From: Susan Haley
Sent: 20 February 2026 10:28
To: 'Jack Tompkins'
Subject: RE: A/16/26/CLP – 31 Palmer Road, Angmering

I have begun reviewing application A/16/26/CLP – 31 Palmer Road, Angmering and noted that on the 'Proposed Elevations Plan 2.002' there is a proposed obscurely glazed non opening circular window. This is not stated within the description on the application form.
<image001.png>

2 West Elevation
Scale: 1:50

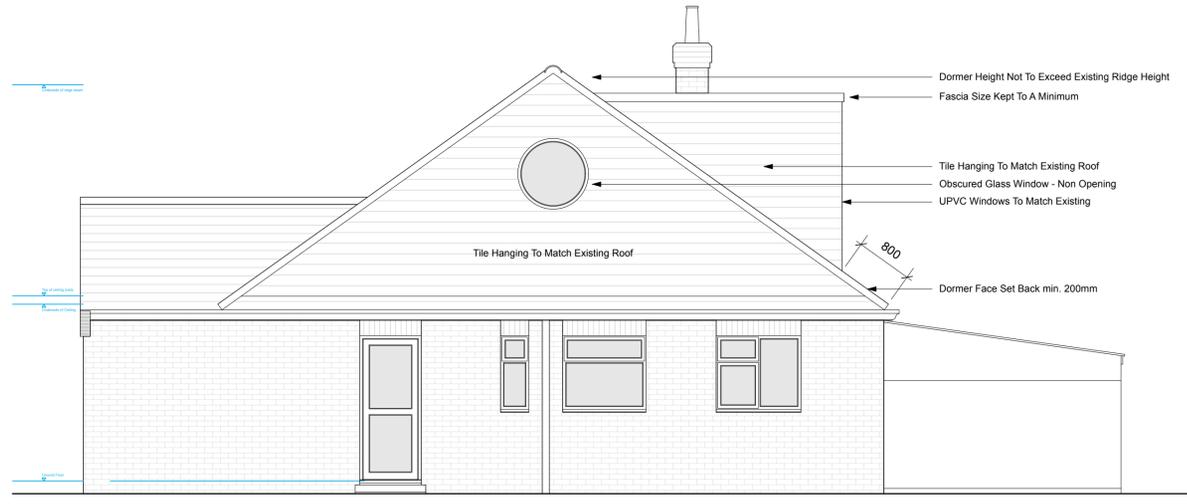
Therefore, to be assessed within this application I suggest an amendment to the proposal's description to 'Lawful development certificate for a proposed hip to gable with dormer to rear elevation, roof windows to the north roof slope **and new fenestration on the west elevation**'.

I can confirm, I am happy with the revised description.
